Our Ref: R/2024/4
File No: 2024/308631
Your Ref: SSD-67588459

SSD-67588459 – Environmental Impact Statement – Powerhouse Ultimo Revitalisation

The development involves a revised proposal for the Powerhouse Ultimo site at 494-500 Harris Street, Ultimo. The City previously provided extensive advice for the previous application. It is understood that this earlier consent has now been surrendered.

drawing	ELEVATION - NORTH																												
drawing no.	A.DA2003	issue Rev G

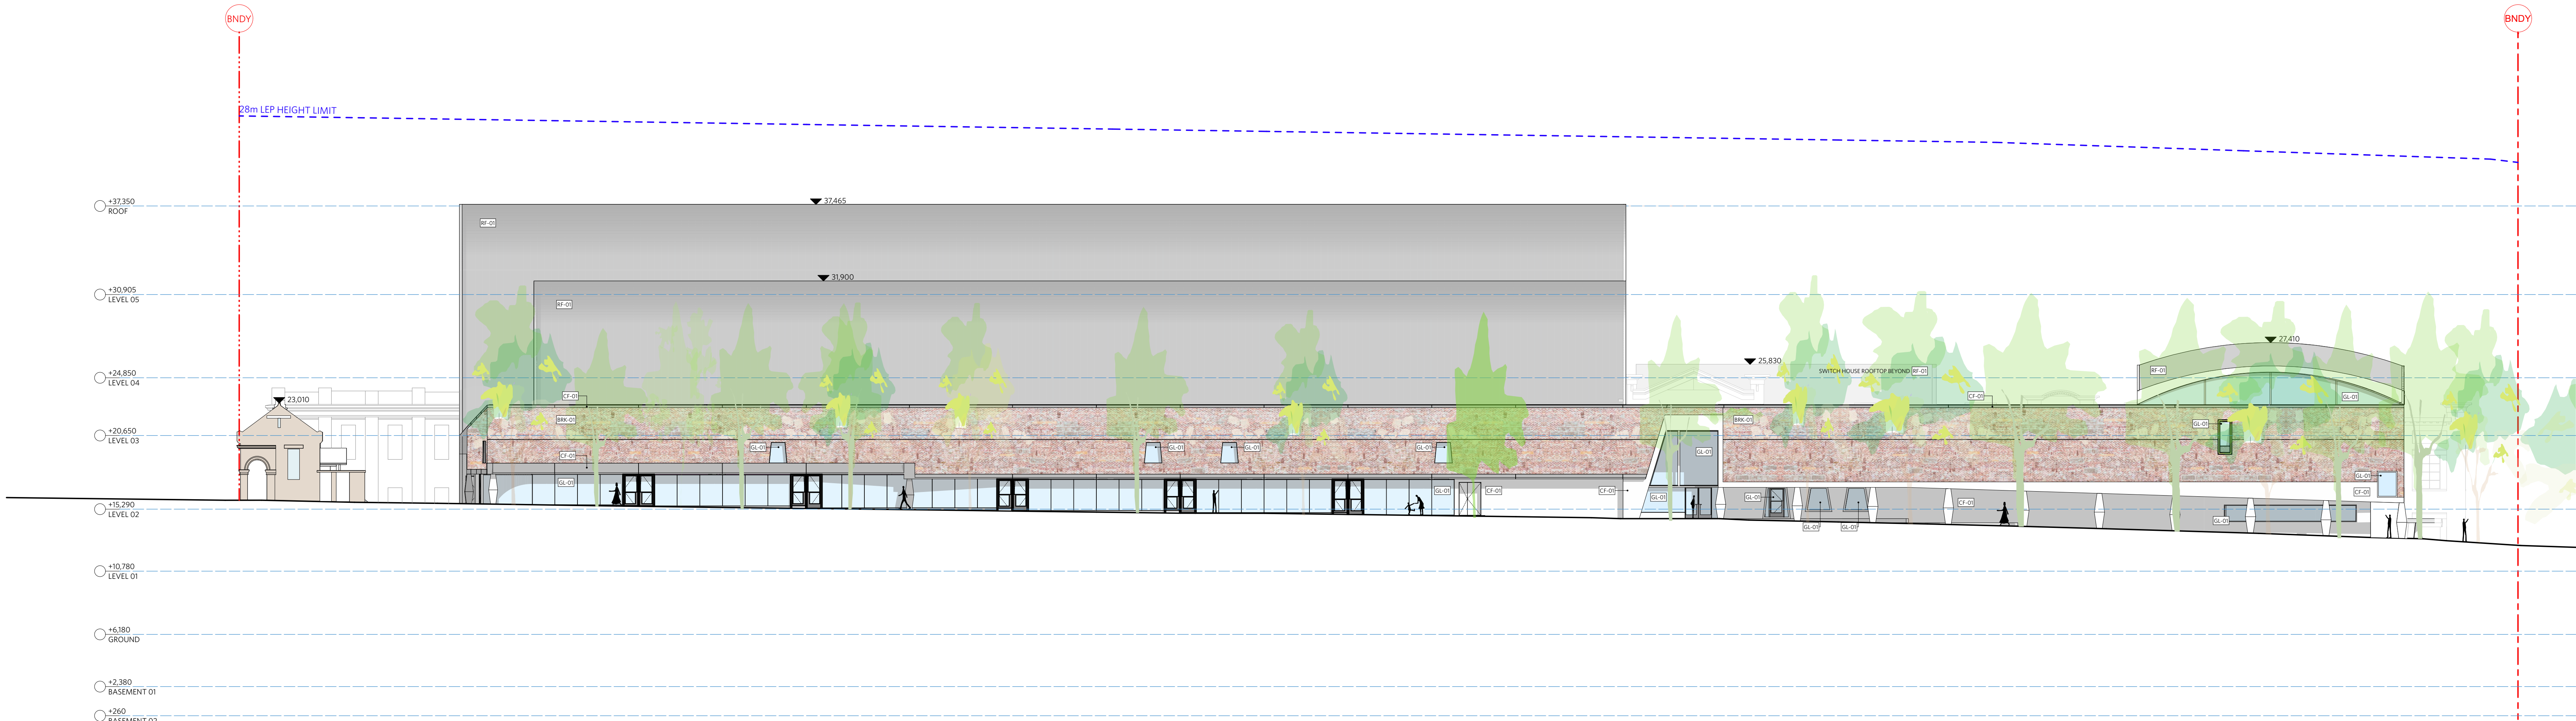
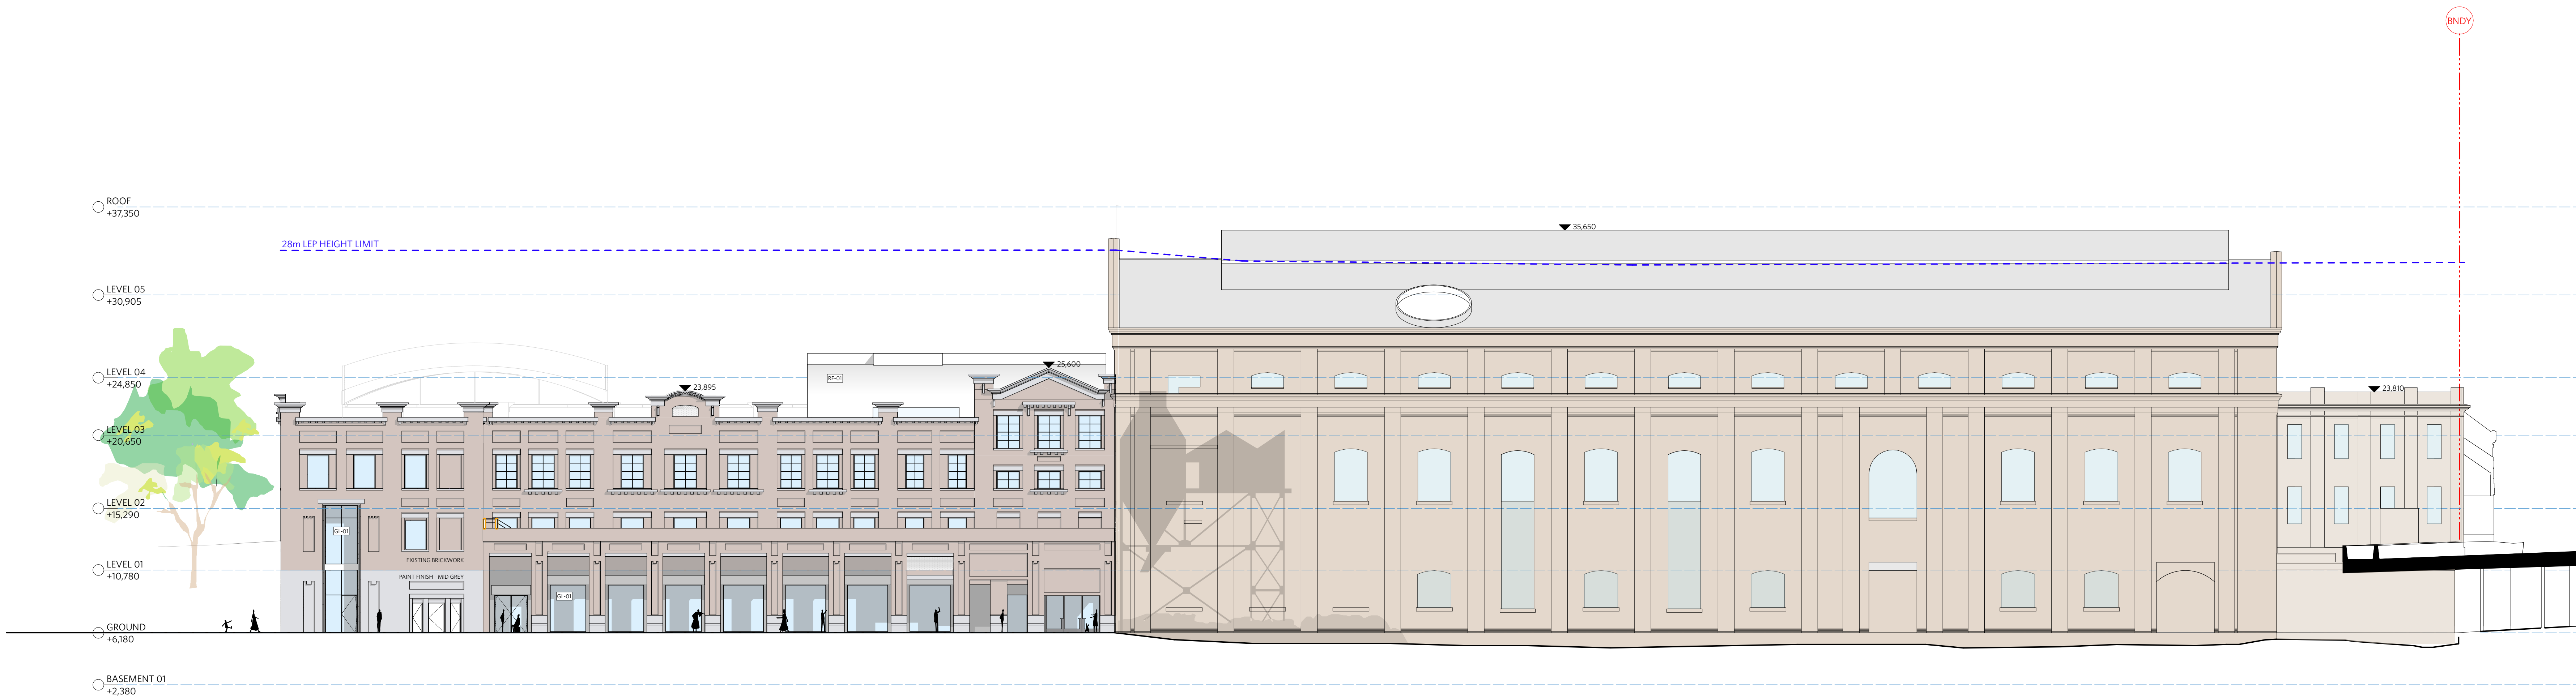
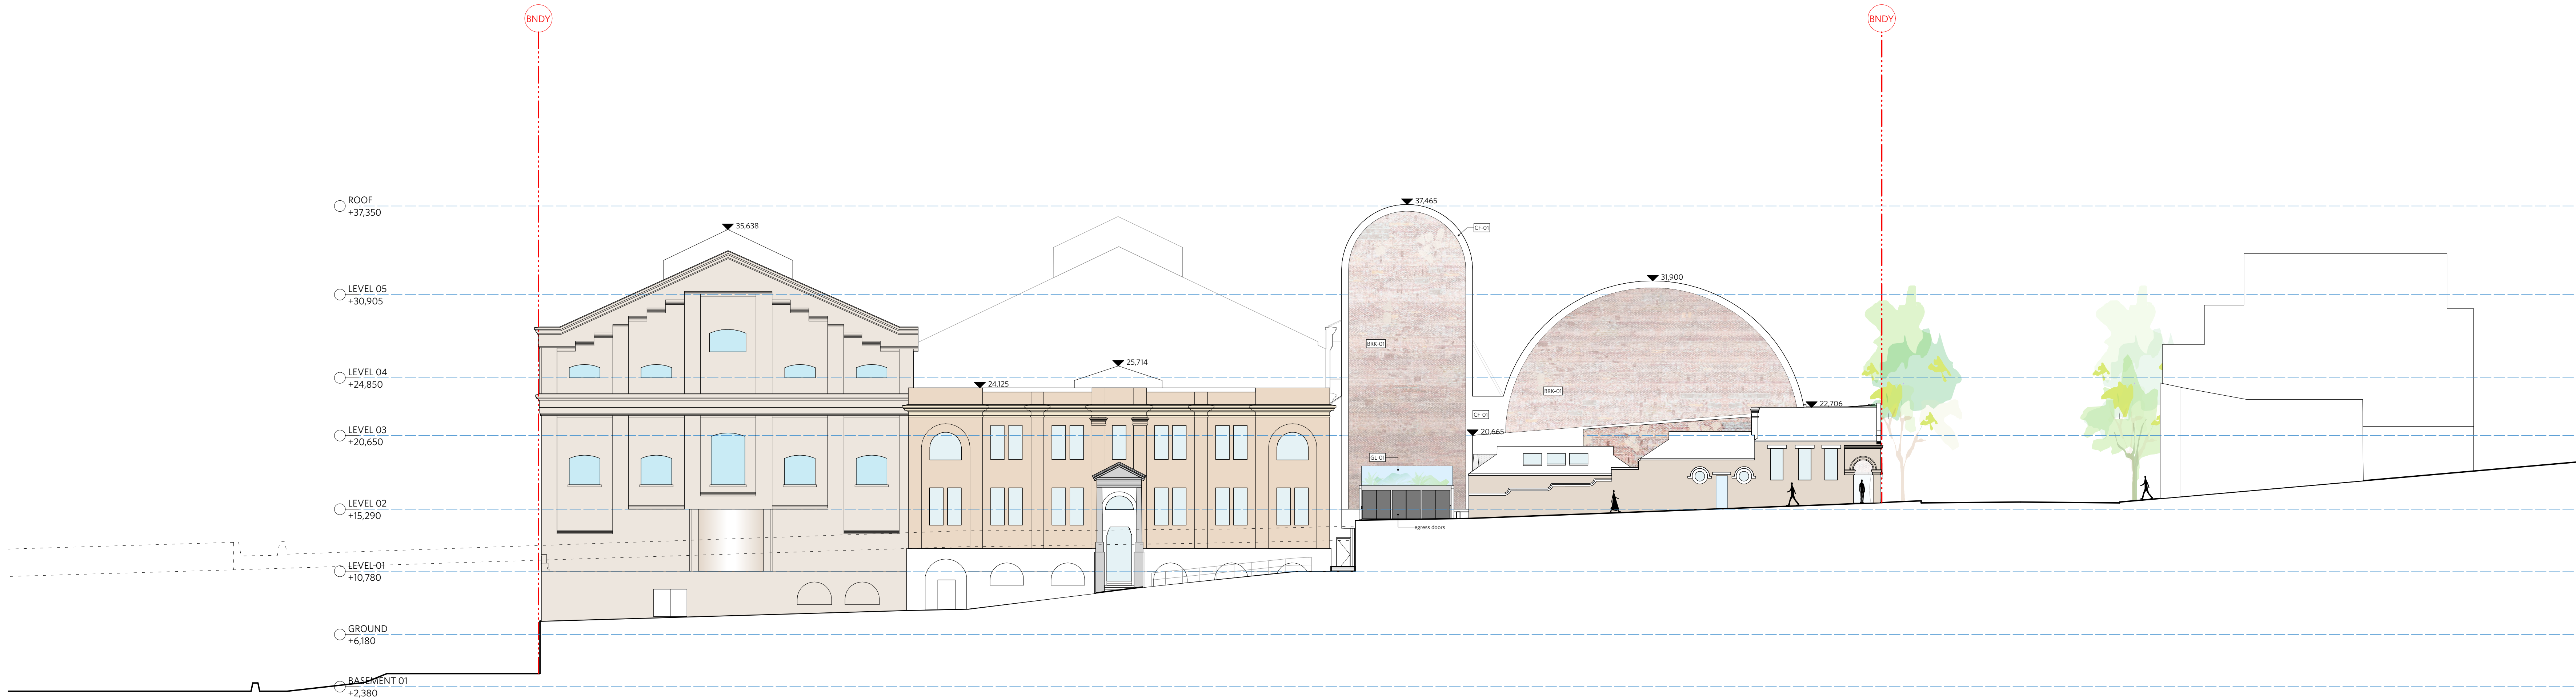
The elevations do not denote the materiality nor construction of the Wran Hall roof. However, the roof vault arch is proposed to be completed. The survey shows that the apex of the curved roof is RL: 31.78 and the elevation when measured is also approximately RL:31.78.

Clarification is required as to whether the intent is to retain the existing roof form and structure and how this would be extended to complete the arch of the barrel. The materiality of the roof is also to be clarified with the continuing use of a high durable long life; lightweight metal roof preferred. Galvanic reactions between dissimilar metals must be avoided or managed.

The northern and southern ends of the Wran hall and the galleria are shown in elevations as brick. More information is required regarding the construction and structural delivery of brick ends to the existing steel super structure. The roof skin is also to be clarified, it is unclear from the renders, what this is intended to be.
